East Anglia One North (EA1N) and East Anglia Two (EA2) Offshore Wind Farms

Planning Inspectorate Reference: EA1N – EN010077, EA2 – EN010078

Deadline 12 – 28 June 2021

**Comments of Suffolk County Council as Lead Local Flood Authority**

Appendix 5: Plan and Cross Sections of Indicative SuDS Basins

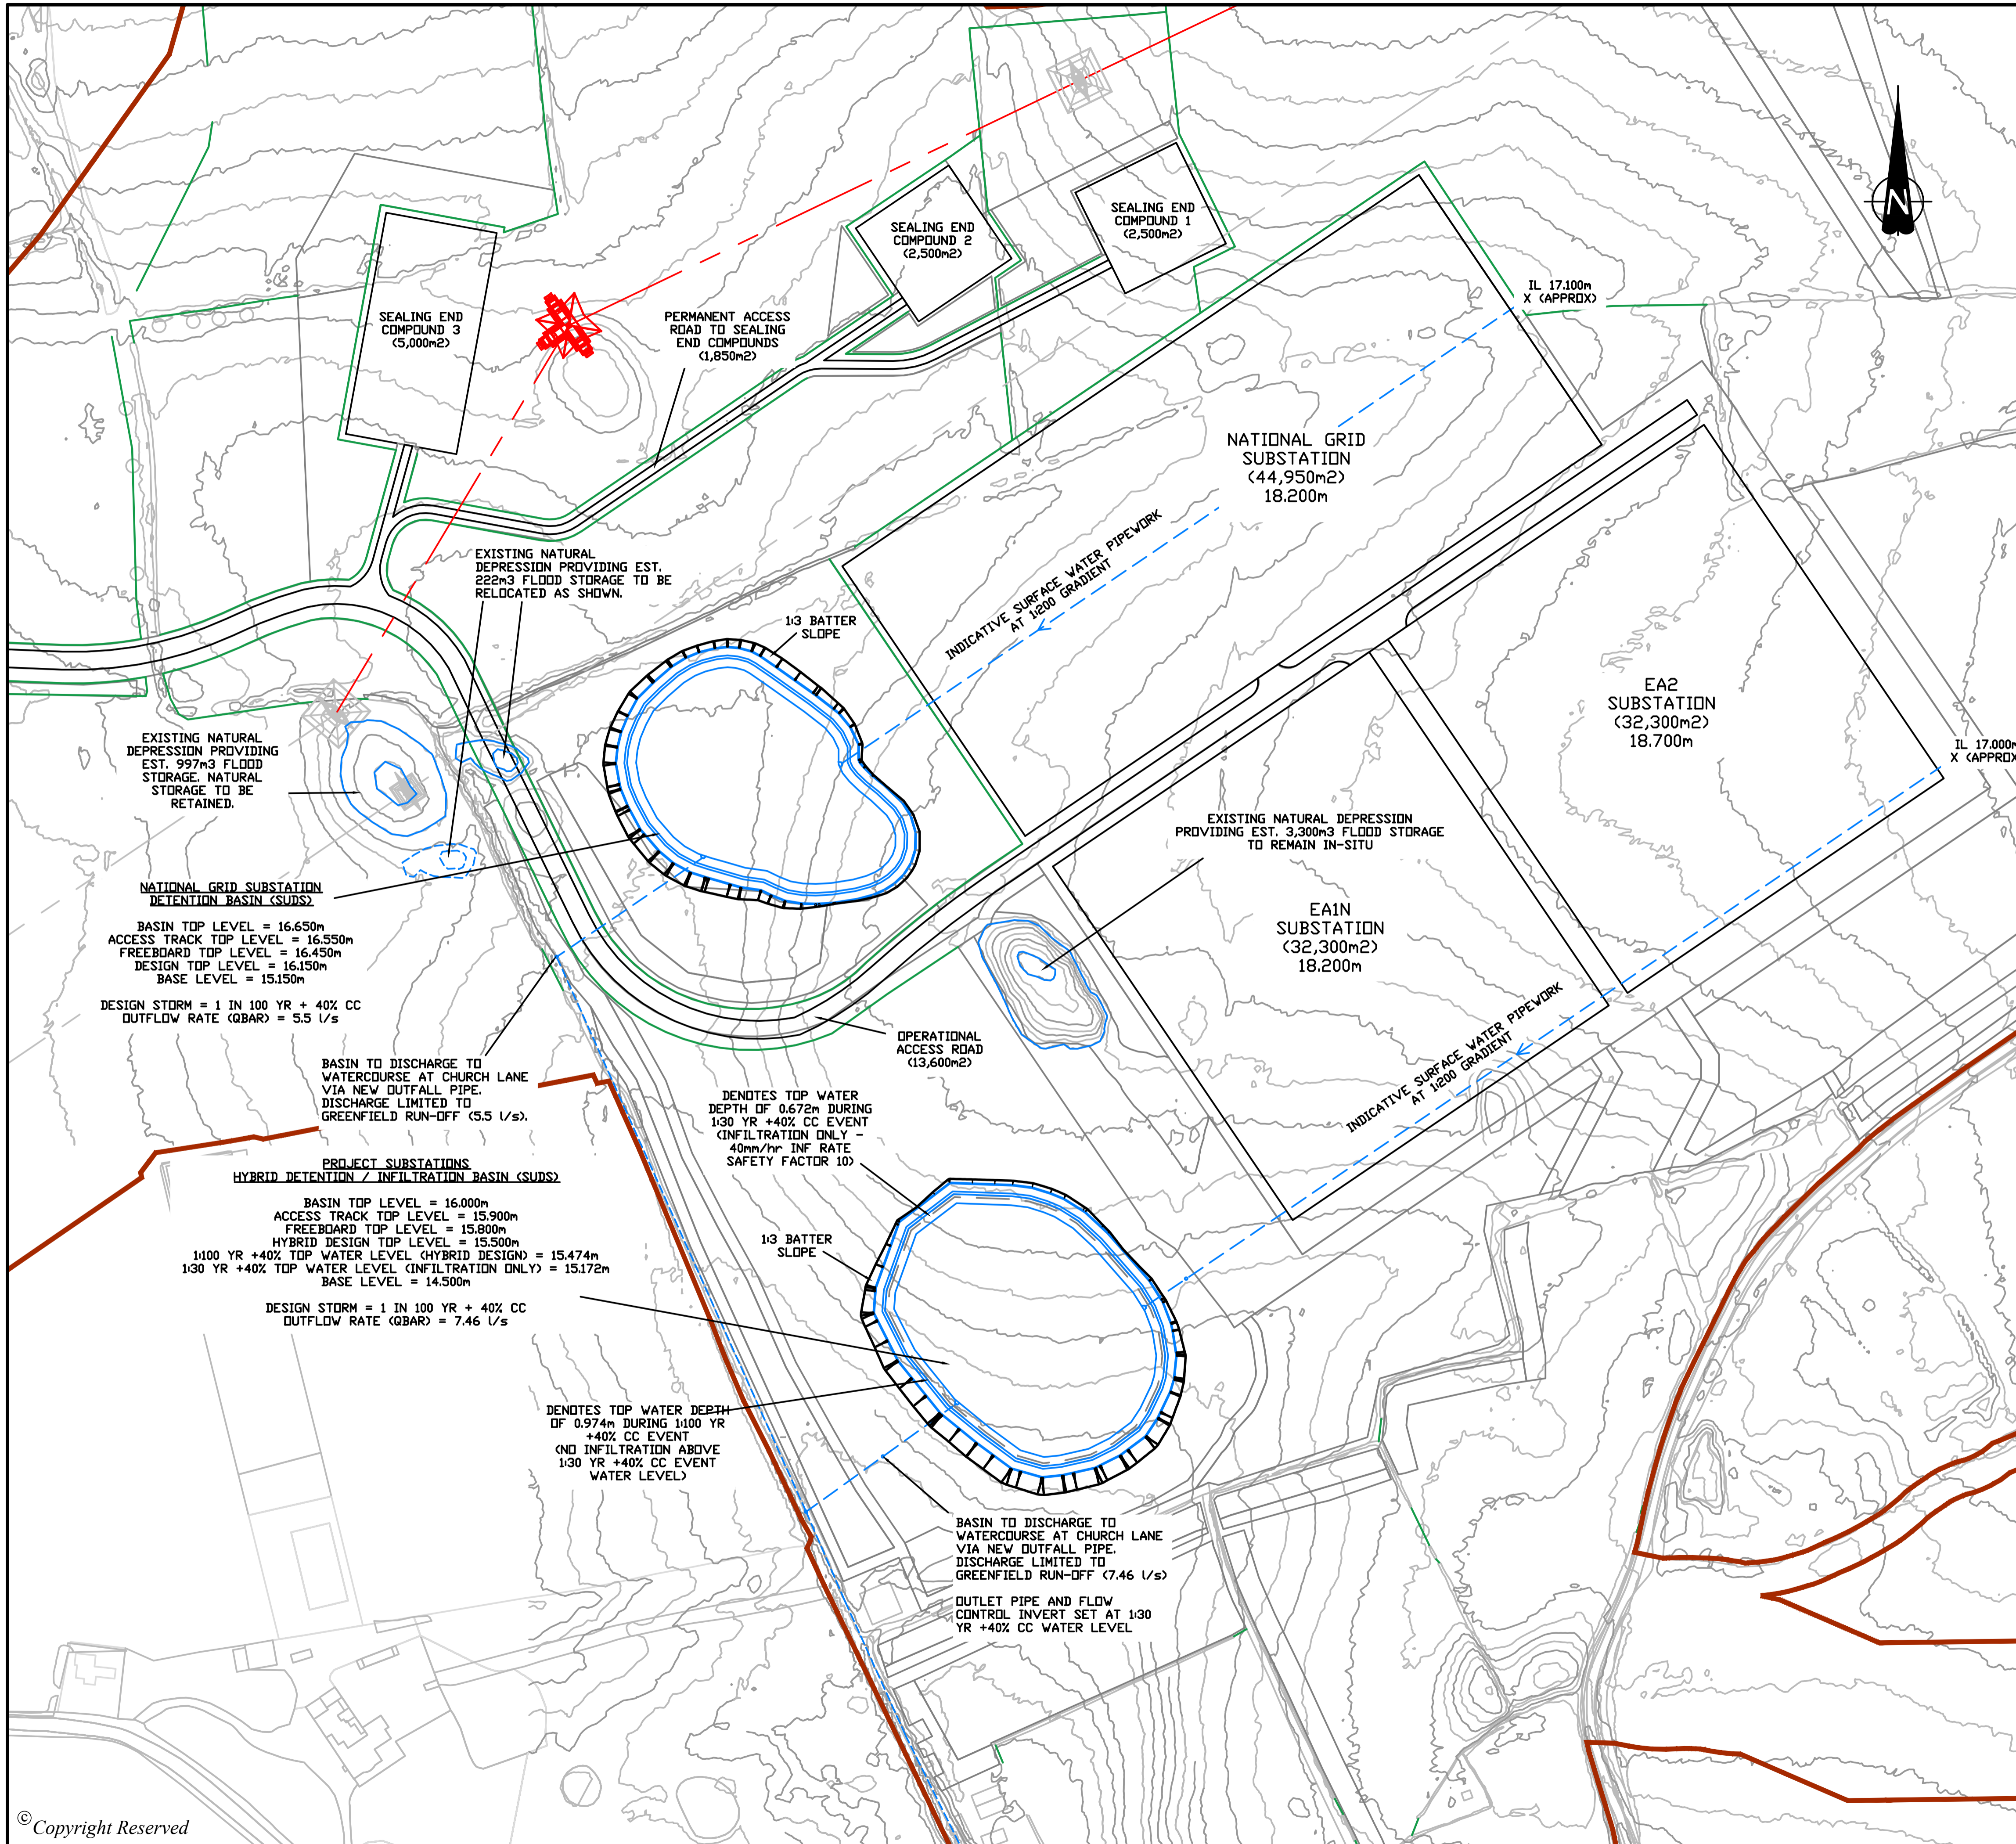
Section 7.3		<p>SCC would have liked to have seen this sensitivity test also undertaken for the discharge from the hybrid basin.</p>
Appendix 2		<ol style="list-style-type: none"> <li>1. SCC query the need for two outfall pipes and would expect one to be sufficient. SCC are however content for this to be confirmed as part of detailed design.</li> <li>2. SCC Highways to confirm acceptability of cover for proposed outfall pipe underneath Church Road.</li> </ol>
Appendix 5		<p>Revised location of existing natural depression is acceptable to SCC</p>

TYPICAL HYBRID DETENTION / INFILTRATION BASIN CROSS SECTION
(PROJECT SUBSTATIONS)

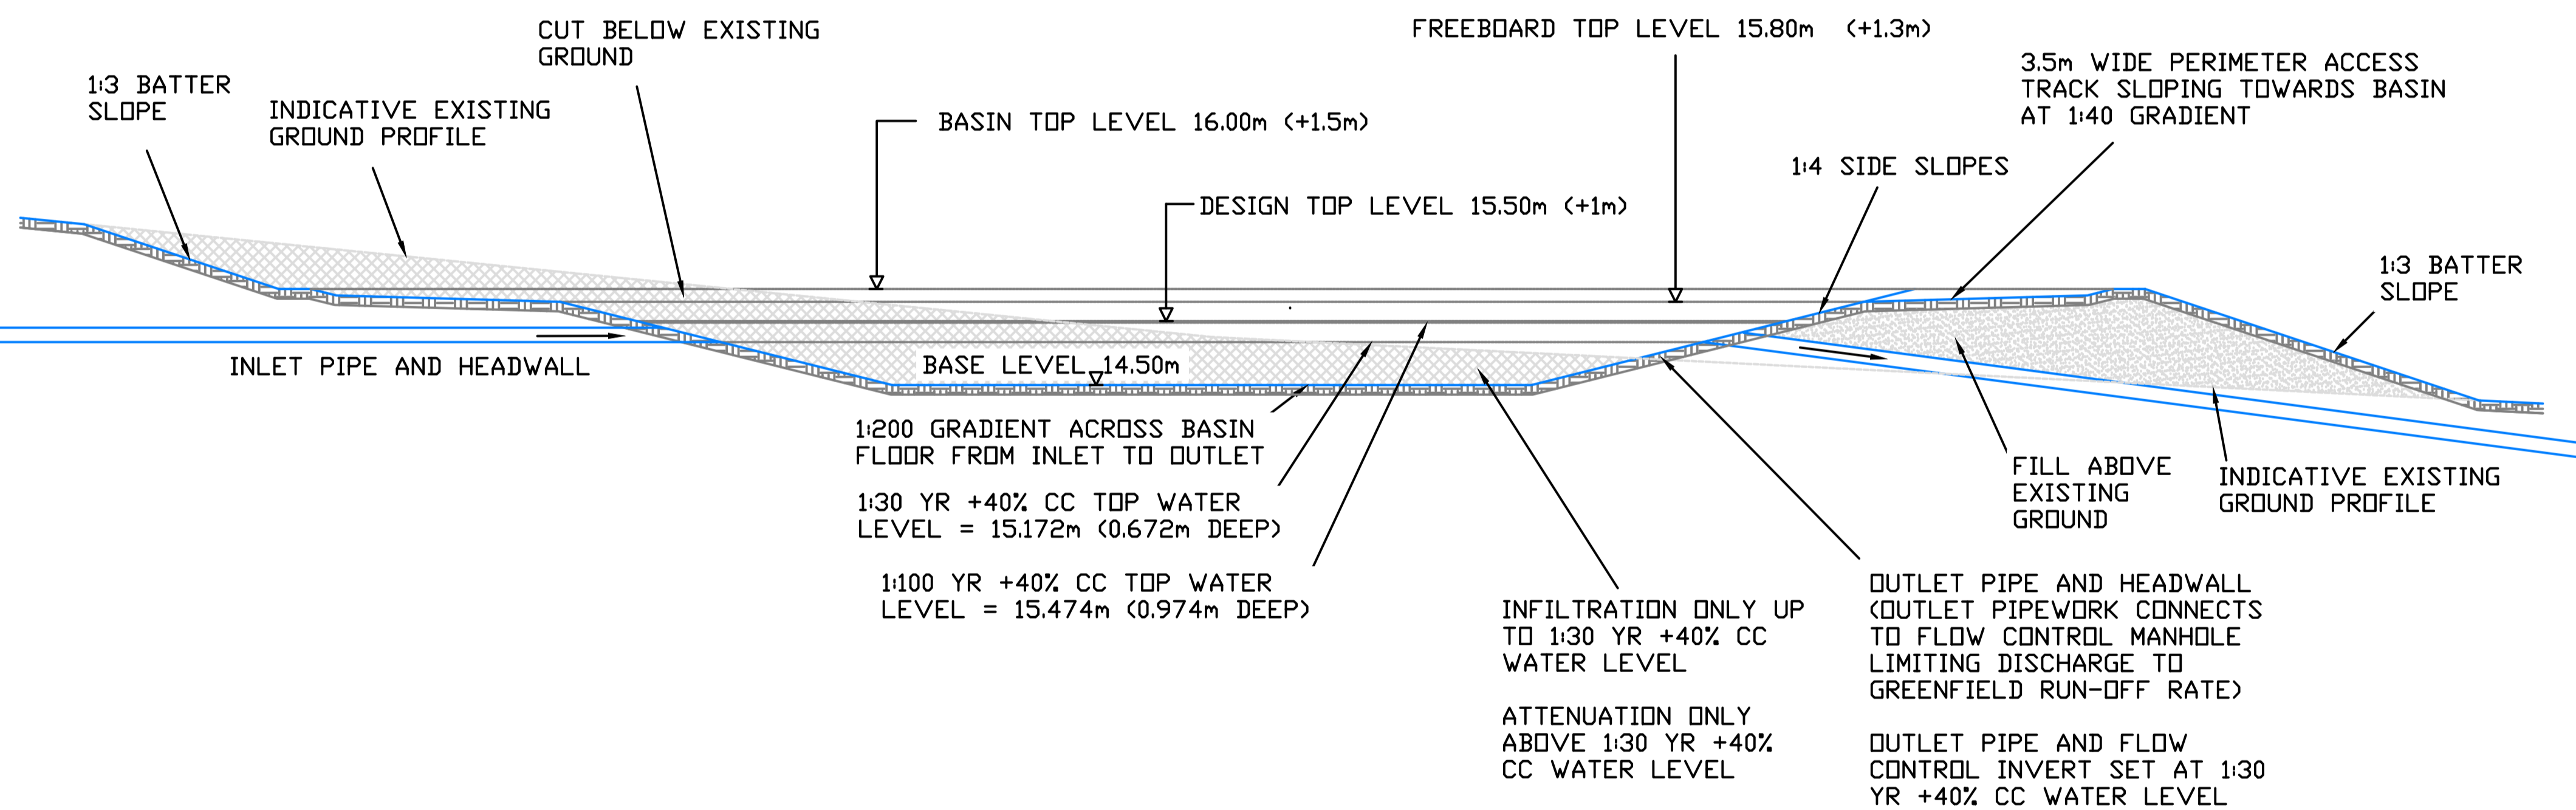
infiltration will remain a practicable method of surface water disposal for the lifetime of the development, due to the low infiltration rates (which would likely be even lower if testing were completed without extrapolation) and the presence of fines. As such, SCC support an attenuation only design for the National Grid sub-station basin.
17	For the onshore substations' basin, the average infiltration rate of the lowest test result for TP015B, TP016B and TP017B is 49.3mm/hr. In order to take a conservative approach at this location, the Applicants have agreed a 40mm/hr infiltration rate with the LLFA for drainage calculations at this outline design stage of the Projects, and agreed with the LLFA to progress a hybrid SuDS basin (i.e. a combination of infiltration and attenuation) at this location.	The lowest infiltration rates for the three tests pits for the Project sub-stations were 63mm/hr, 35mm/hr & 50mm/hr. Only one of these three test pits soil logs recorded the presence of a silt material at depth (TP015B) and this was only described as 'slightly silty'. Given the testing was extrapolated, it was agreed with the Applicant to work off an average infiltration rate of 40mm/hr for design purposes. Whilst this rate could be viewed as acceptable for an infiltration only approach, SCC LLFA note there are no tests towards the northern edge of the indicative basin area illustrated in Appendix 3 and nearby TP330B failed to record an acceptable infiltration rate. This variability of soil properties will need to be assessed further at detailed design, but ultimately is unlikely to be reliable enough for an infiltration only approach, especially when considering the risk to the nearby village of Friston. As such, SCC LLFA support the proposal for a hybrid (infiltration & attenuation) solution for the Project sub-stations.

93	For the onshore substations SuDS basin, the average infiltration rate of the lowest test result for TP015b, TP016b and TP017b is 49.3mm/hr. In order to take a conservative approach at this location, the Applicant has agreed a 40mm/hr infiltration rate with the LLFA for drainage calculations at this outline design stage of the Projects (with storage for a 1 in 30 year return period (plus 40% for climate change)). It has been agreed with the LLFA to progress a hybrid SuDS basin (i.e. a combination of infiltration and attenuation) at this location.	For clarity, SCC have agreed the hybrid approach on the basis that infiltration is facilitated (using an infiltration rate of 40mm/hr and FoS of 10) for the 1:30+40% rainfall event. The 1:100+40% event is accommodated within the same basin, above the water level for 1:30+40%, but discharges through a positive outfall to Friston Main River at Qbar.
